CITY OF ALBUQUERQUE

**RE: Winrock Regal Cinema Temporary Parking
Amendment to Road B Extension
2100 Louisiana Blvd NE
Grading and Drainage Plan Stamp Date: 9/3/19
Hydrology File: J19D058H**

Based on submittal received on 9/4/19, the Grading and Drainage Plan is for Site Plan for Building Permit (AA), Grading Permit and Paving Permit.

GRADING PLAN

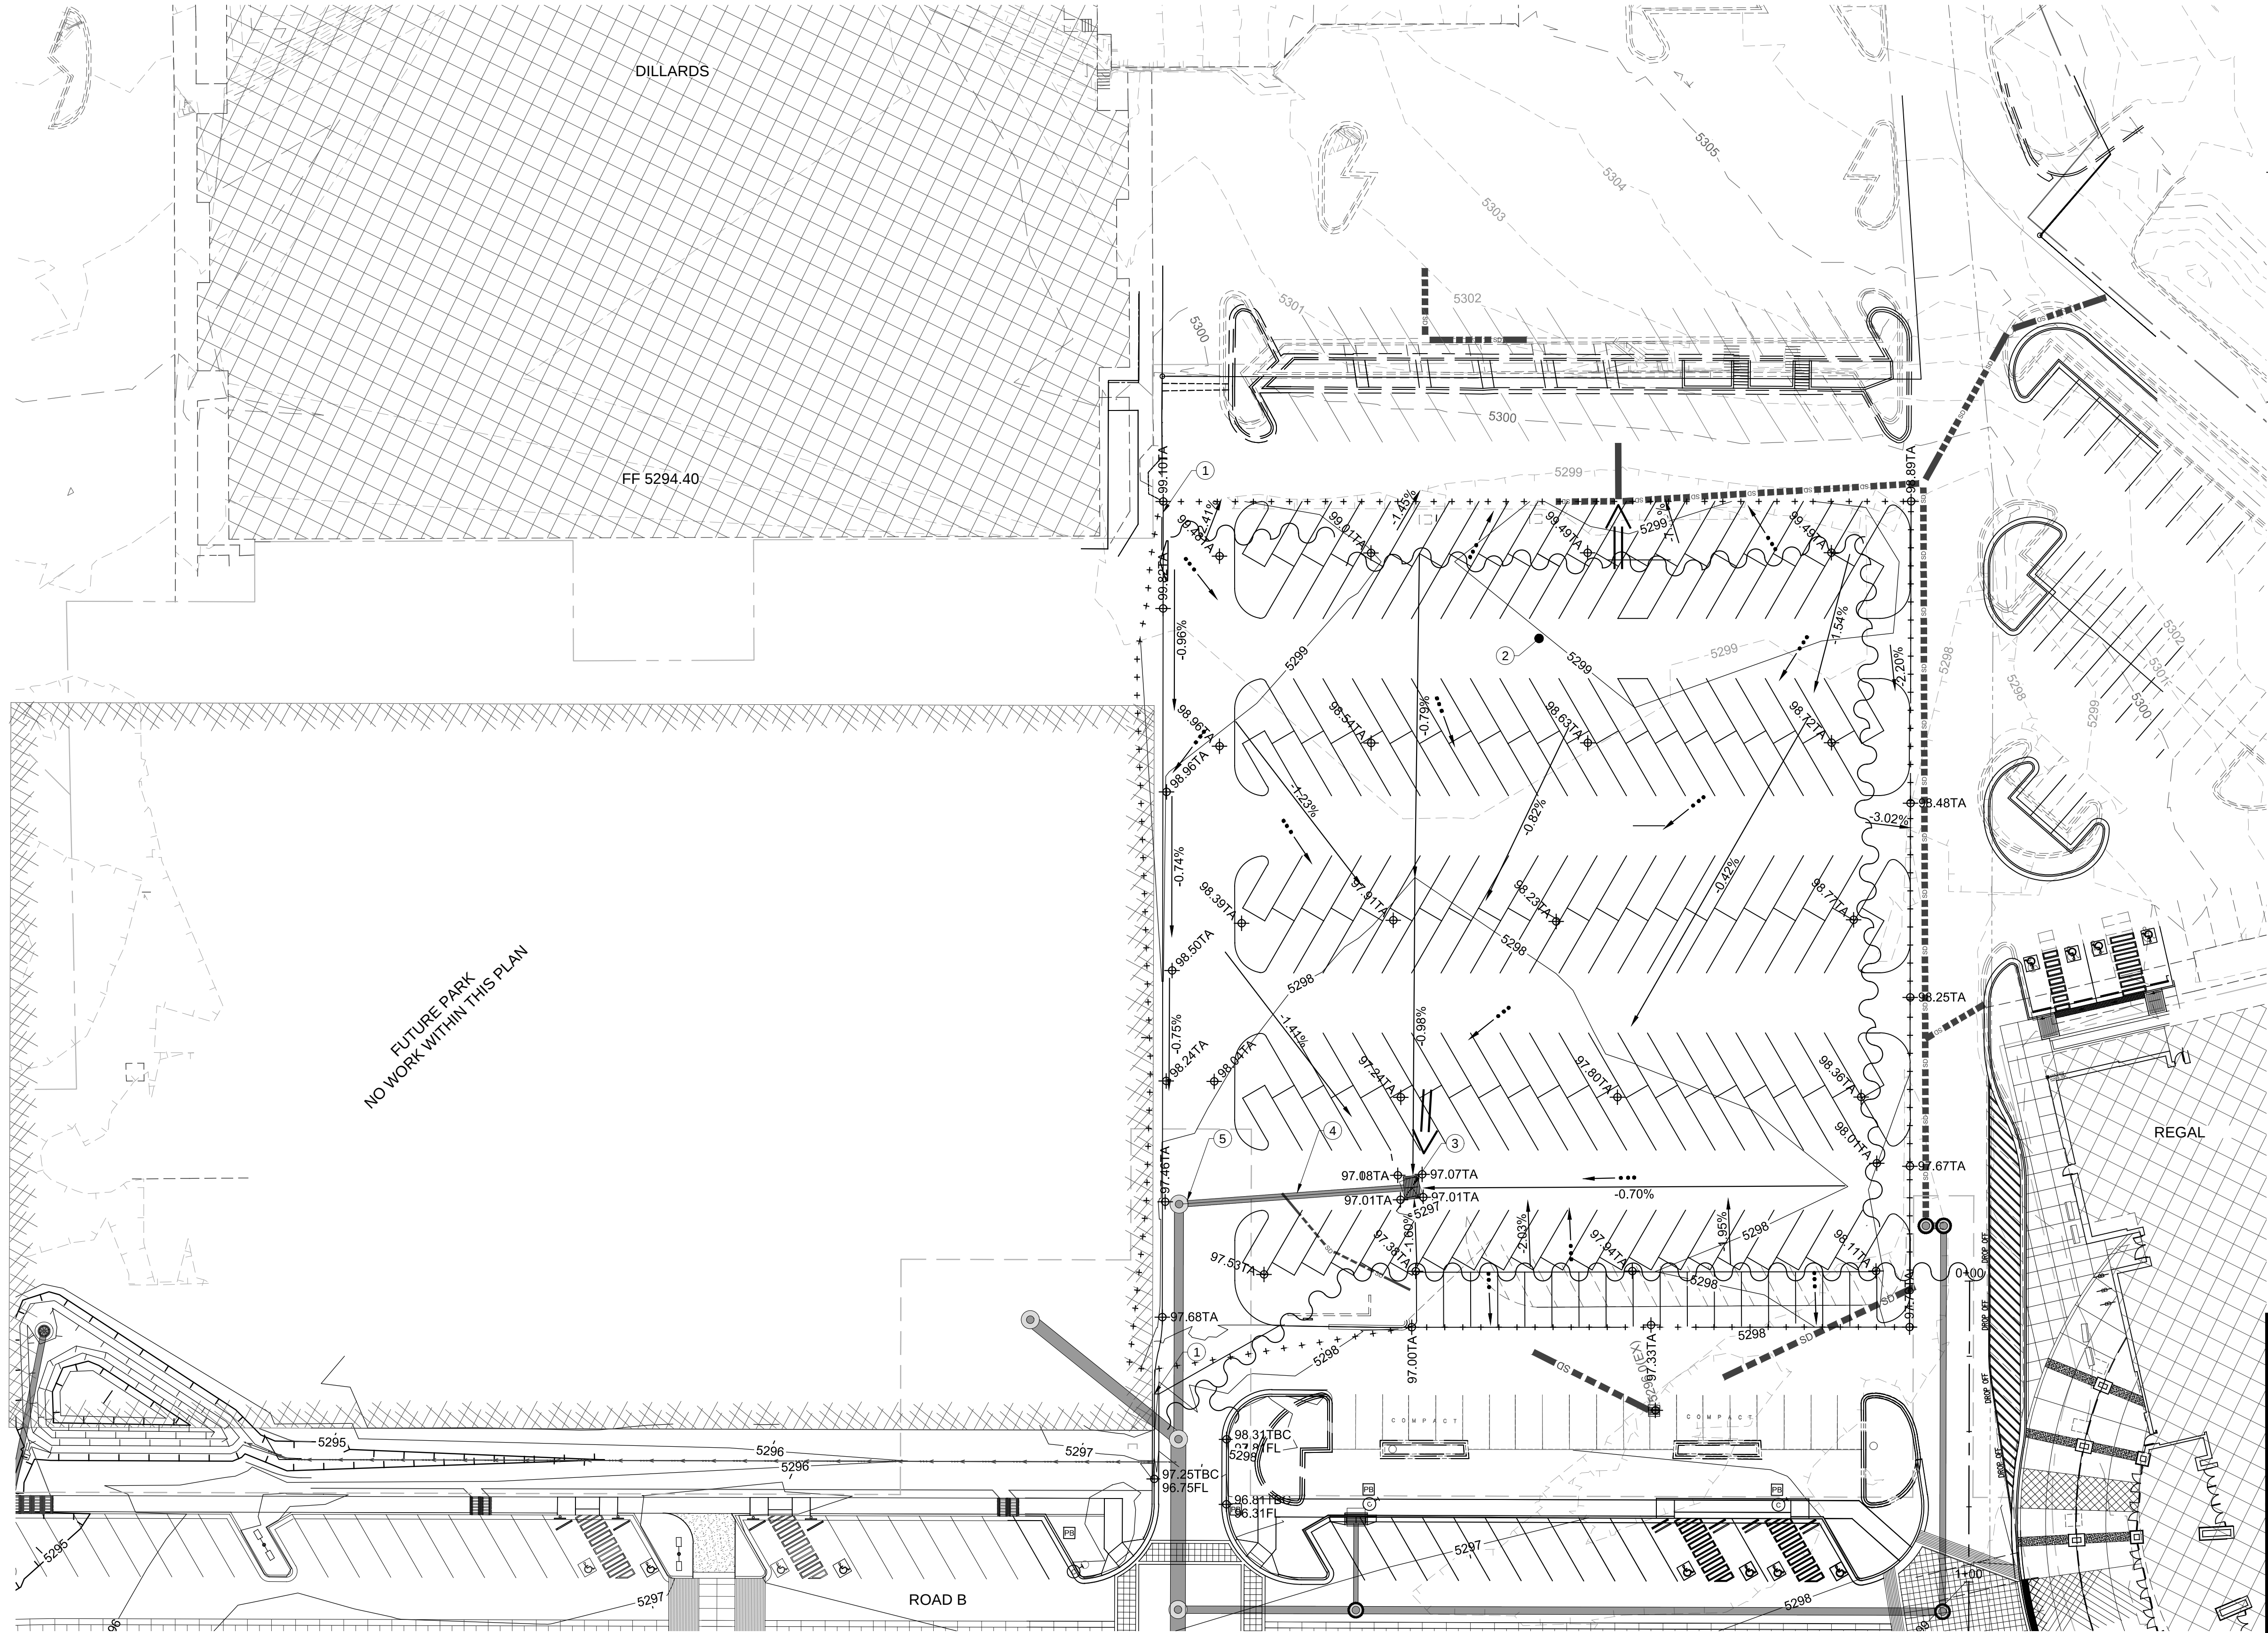
1. For information. Construction notes 3 and 4 need to be swapped.
2. For Information. The ponds being proposed will need to be surveyed, certified, and inspected as part of the Work Order close-out.
3. As a reminder, if the project total area of disturbance (including the staging area and any work within the adjacent Right-of-Way) is 1 acre or more, then an Erosion and Sediment Control (ESC) Plan and Owner's certified Notice of Intent (NOI) is required to be submitted to the Stormwater Quality Engineer (Doug Hughes, jhughes@cabq.gov, 924-3420) 14 days prior to any earth disturbance.
